From: Jaclyn Burns <Jaclyn.Burns@oberon.nsw.gov.au>
Sent: Wednesday, 21 January 2015 3:59 PM
To: Pamela Morales
Subject: RE: Oberon Timber (Borg) - DA 27/95 Modification 7 - Additions to MDF Facility (Oberon LGA)

The proposed modification involves additions to the existing MDF facility including a new debarker and bark building, temporary hardstand area and relocation of various plant and equipment. The modification application has been made under section 75W (Part 3A) of the *Environmental Planning and Assessment Act 1979* and it relates to a Part 4 consent, which was granted by the Minister in October 1995.

Site Plan

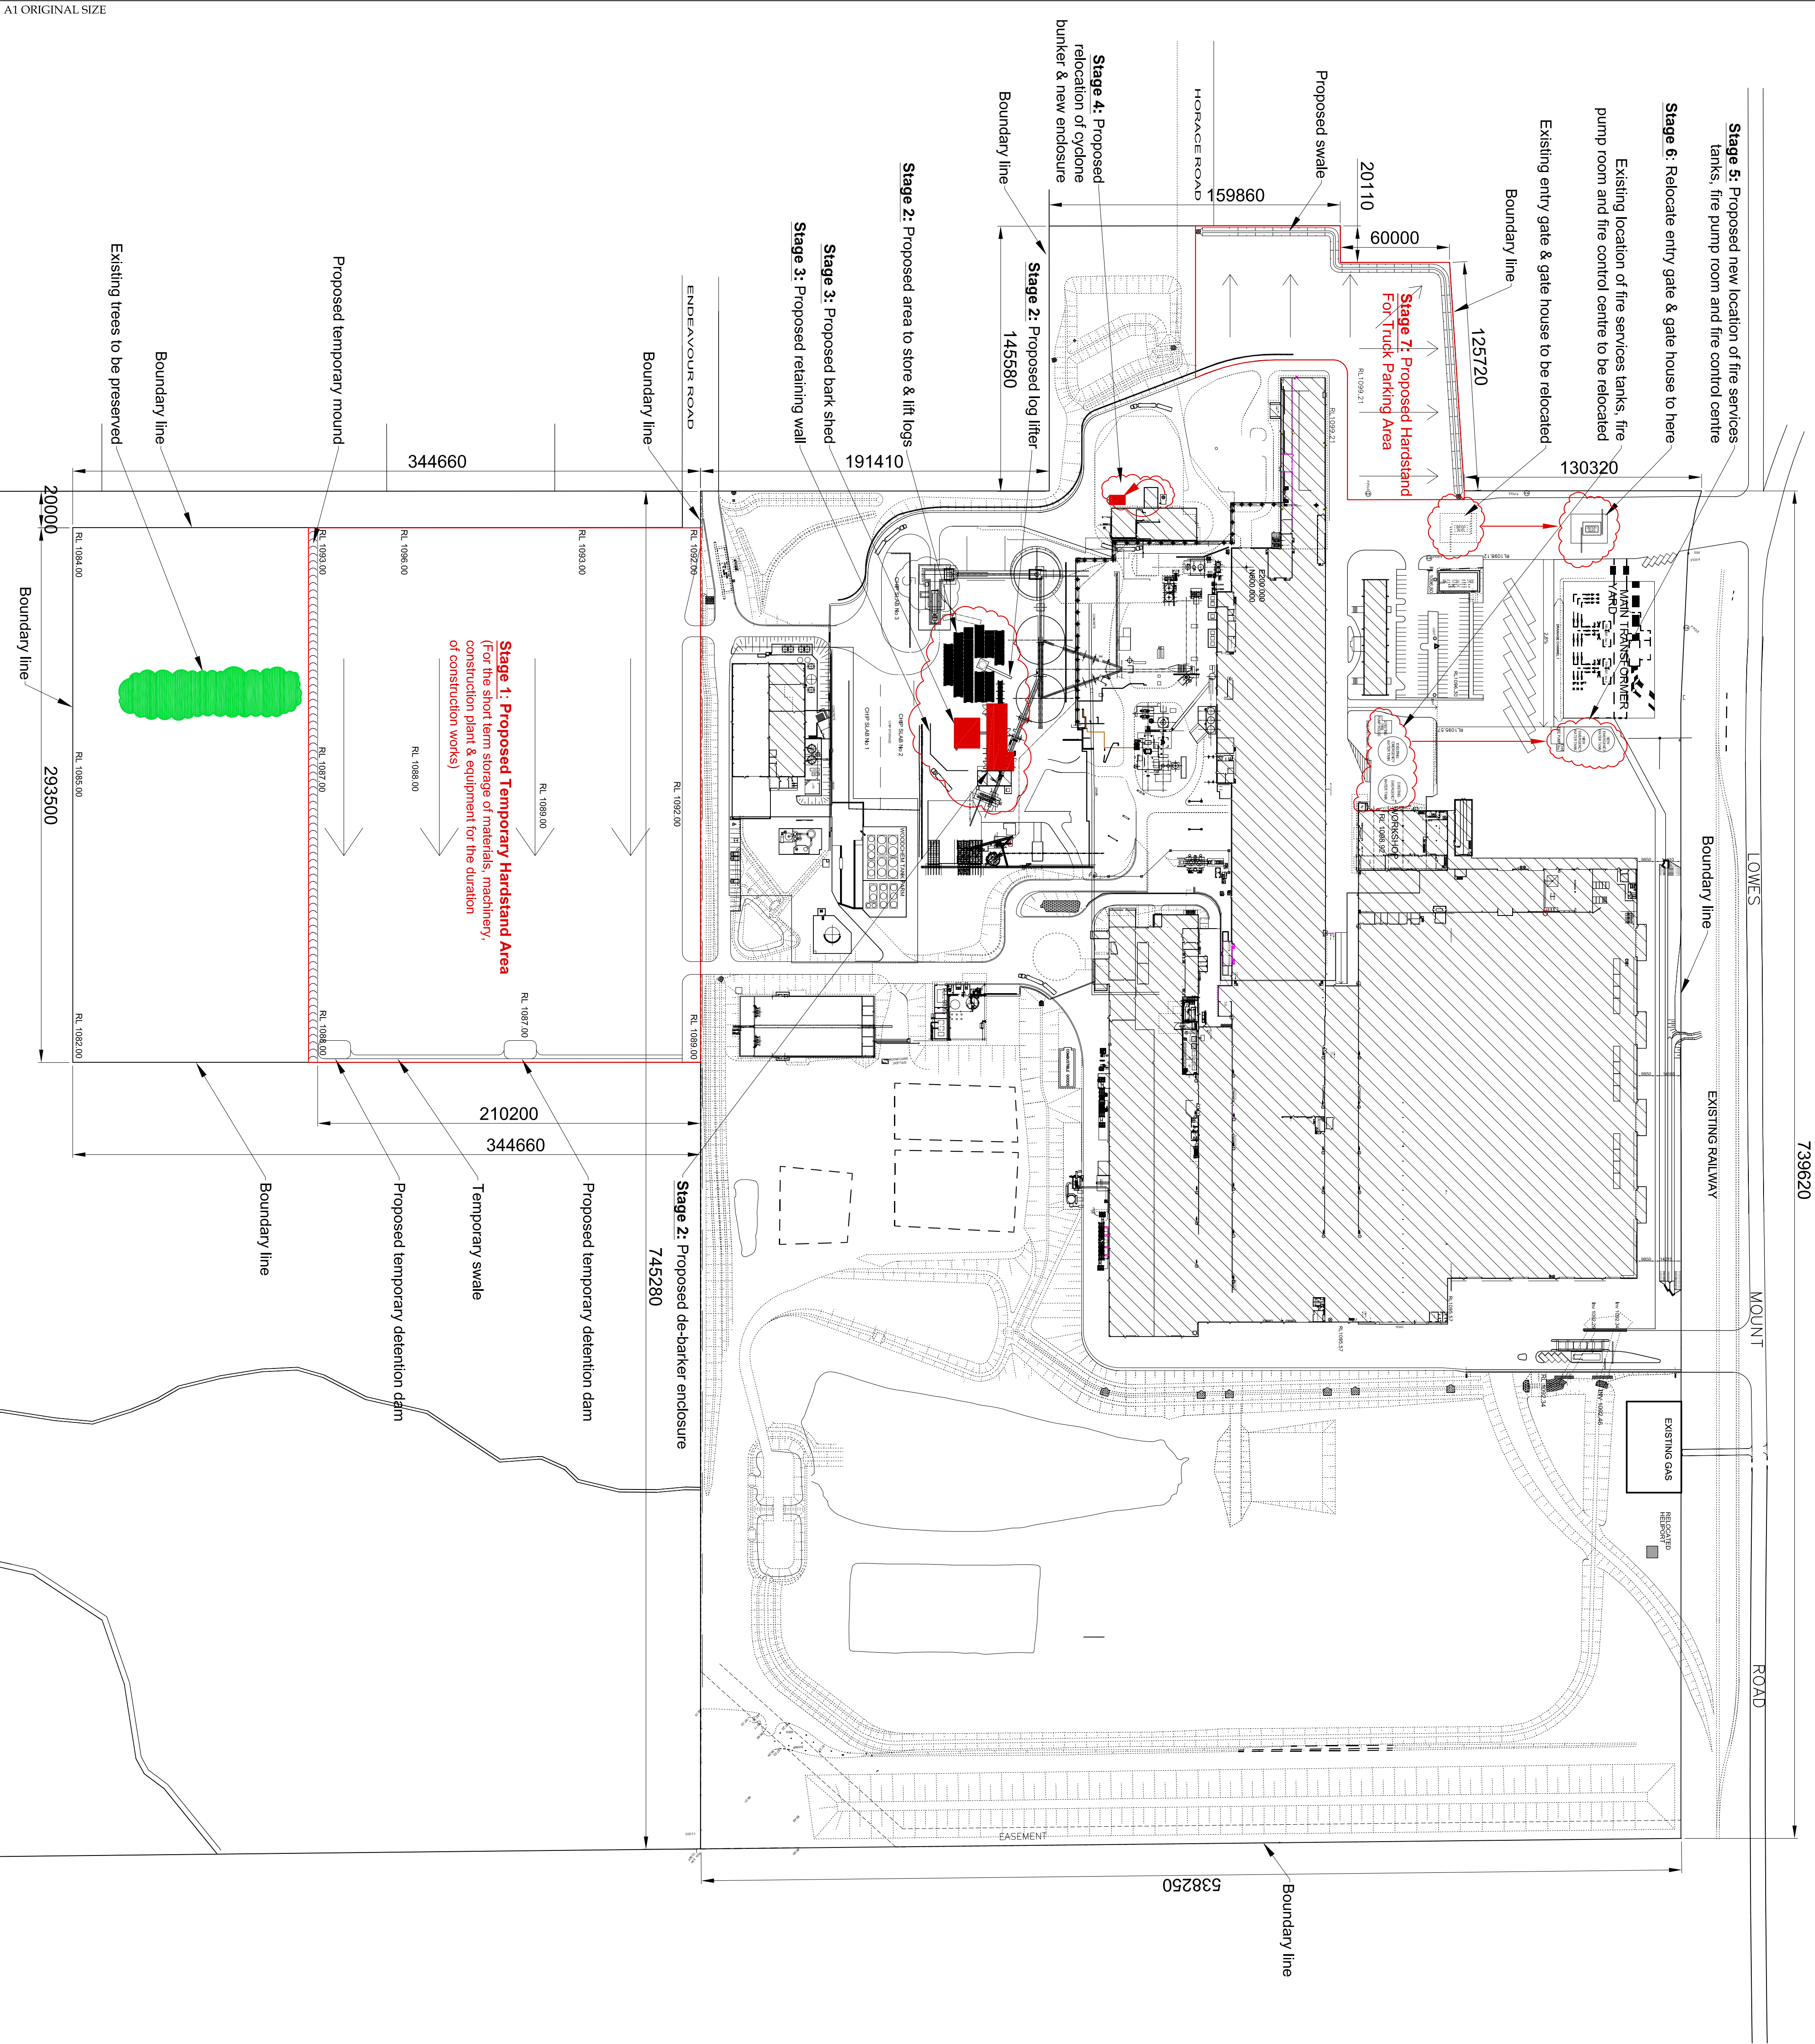
3. What will the temporary hard stand area be utilised for after the prescribed 12 month period?
4. Is the applicant aware, as no comment has been made within the assessment, that Lot 2902 is contaminated by past agricultural use, including a sheep dip, as identified in report by PPK in 2002. Has this site been remediated?
